Staffordshire County Council response to ExA's First Questions

Ref:	Question to:	Question:	SCC Response:
11.4	Applicant DCC Staffordshire County Council (SCC)	Heavy goods vehicles (HGV) Paragraph 5.14.14 of NPS EN-1 states that requirements may be added to a consent where there is likely to be substantial HGV traffic that control numbers and possibly routing of HGV movements in a specified period during construction; make sufficient provision for HGV parking and facilities; and ensure satisfactory arrangements for reasonably foreseeable abnormal disruption. Paragraph 2.10.123 of NPS EN-3 states that Applicants should assess the various potential routes to the site for delivery of materials and components where the source of the materials is known at the time of the application and select the route that is the most appropriate. Paragraph 2.10.125 includes that Applicants should ensure all sections of roads and bridges on the proposed delivery route can accommodate the weight and volume of the loads and width of vehicles. Where modifications to roads and/or bridges are required, these should be identified, and potential effects addressed. DCC [RR-078] considers that further assessme

Figure 10.2: Scenario 1 Preferred Construction Vehicle Routing

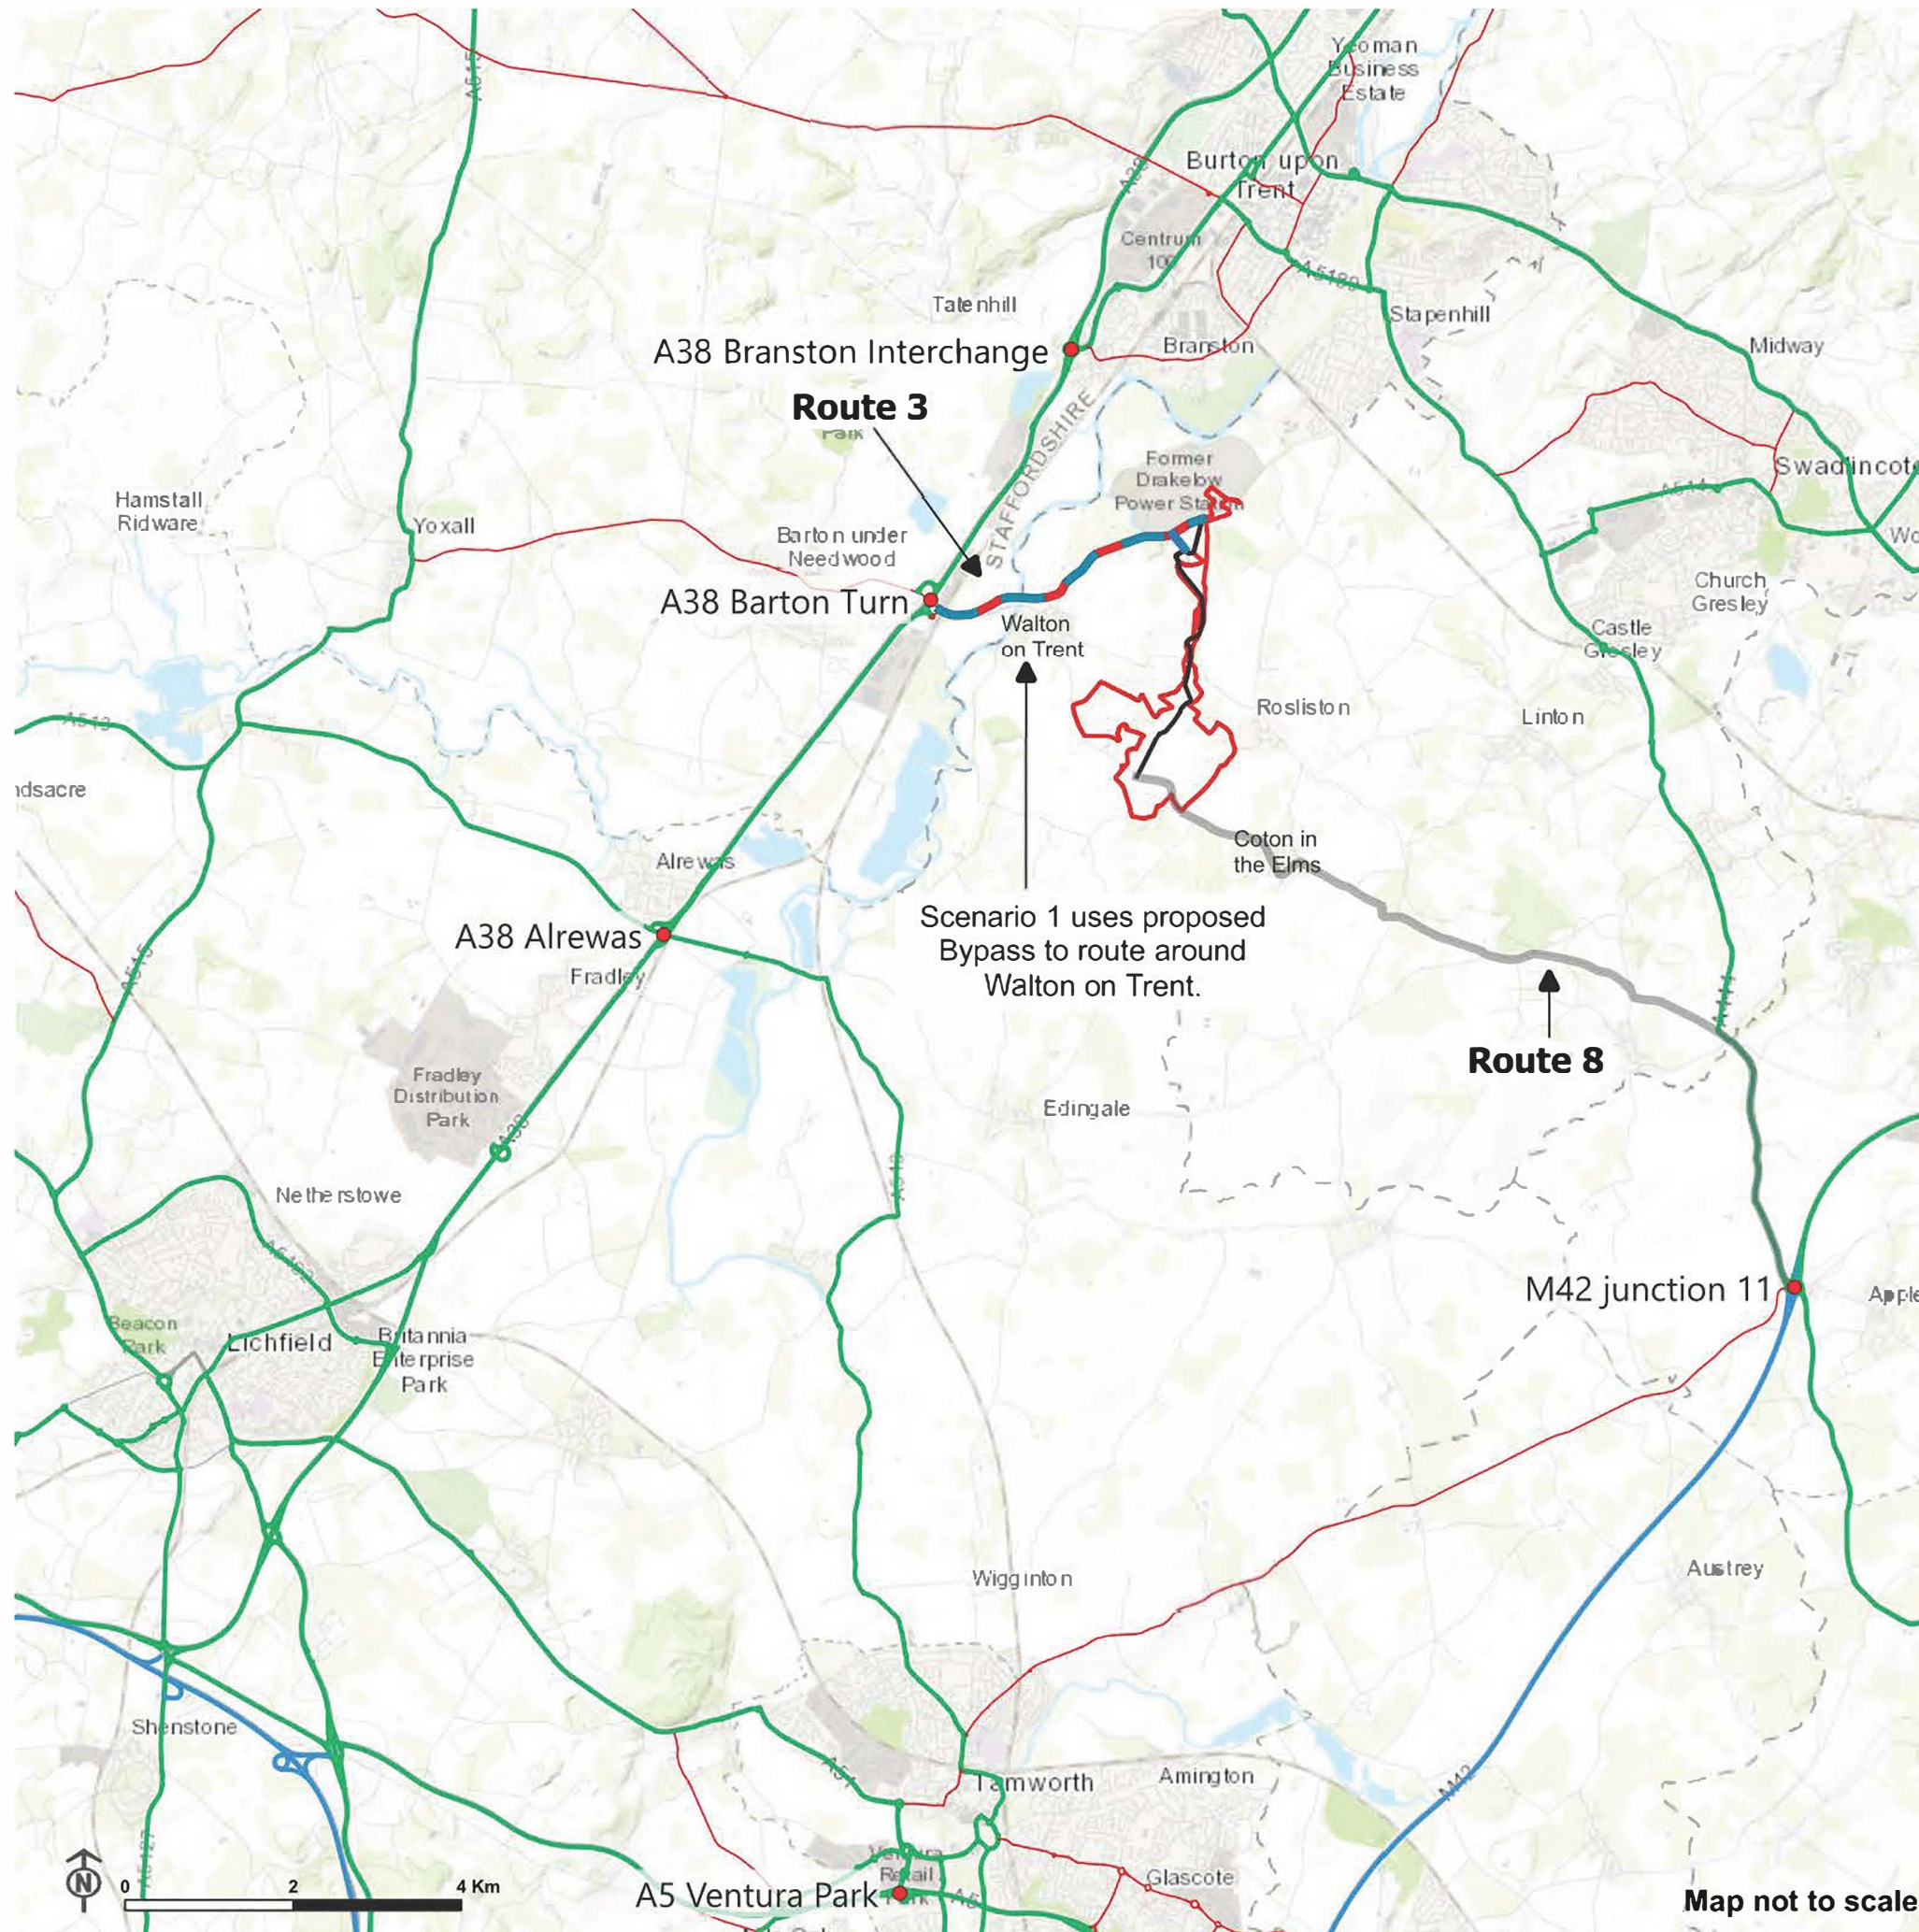
<p>associated with the construction and decommissioning of the proposal, particularly regarding the impacts of goods vehicle access through urban areas and along relatively quiet country roads benefiting from an environmental weight limit. SCC [APP-155 Table 2.1] is quoted as saying that the route through Stapenhill is within Staffordshire and is particularly sensitive to HGV usage and will need careful consideration. The Applicant [AS-015 Figure 10.3] indicates that the likely construction route for HGV would be on Route 6 through Stapenhill.</p> <p>a) Please could the Applicant, following consultation with DCC, update its assessment and secured mitigation measures as necessary?</p> <p>b) Please could DCC advise if it has any outstanding concerns on the Applicant's updates?</p> <p>c) Do SCC or DCC have any comments on the mitigation measures provided for Route 6?</p> <p>d) Should it be secured that construction route Scenario 2A would only be used if Scenario 1 (using Walton-on-Trent bypass) is not available [APP-155 paragraph 10.149]?</p>

Figure 10.3: Scenario 2A Likely Construction Vehicle Routing

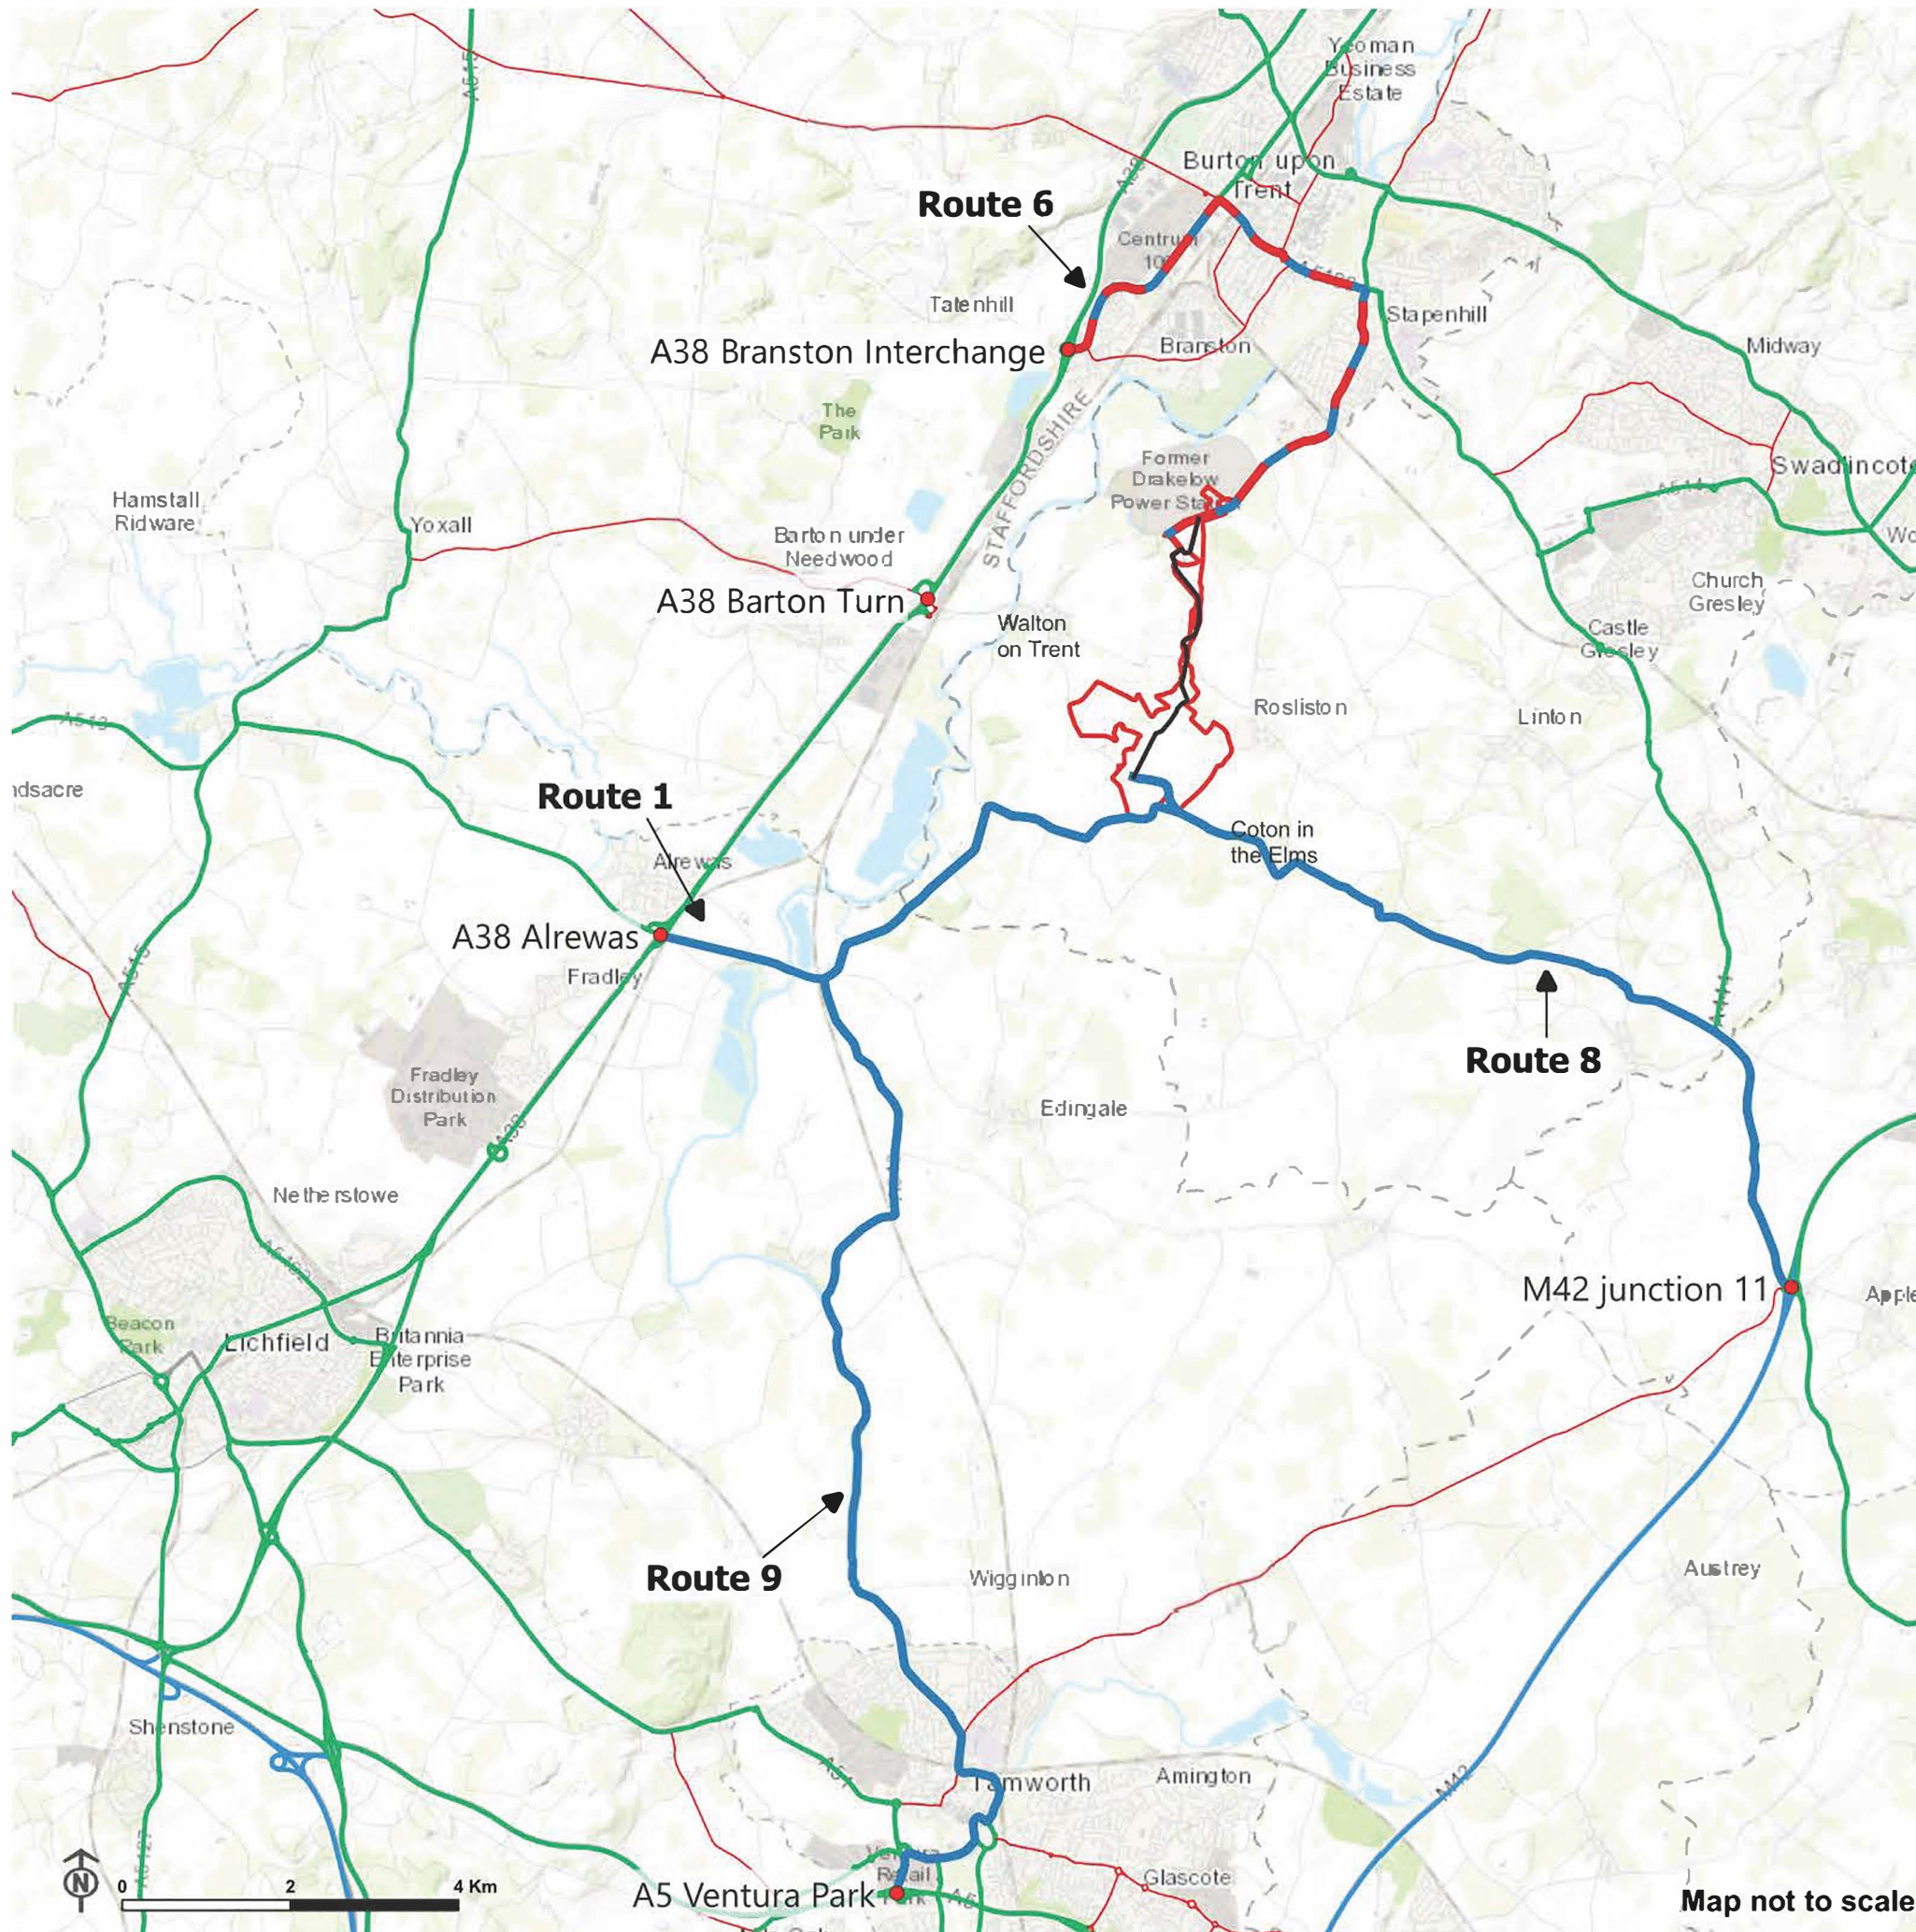
<p>e) Should it be secured that construction route Scenario 2B would only be used if Scenarios 1 and 2A are not available?</p> <p>f) Are any more measures required to ensure that no construction traffic would go through Walton-on-Trent?</p> <p>g) Are there any concerns about whether sections of roads and bridges on the proposed routes can accommodate the weight and volume of the loads and width of vehicles?</p>
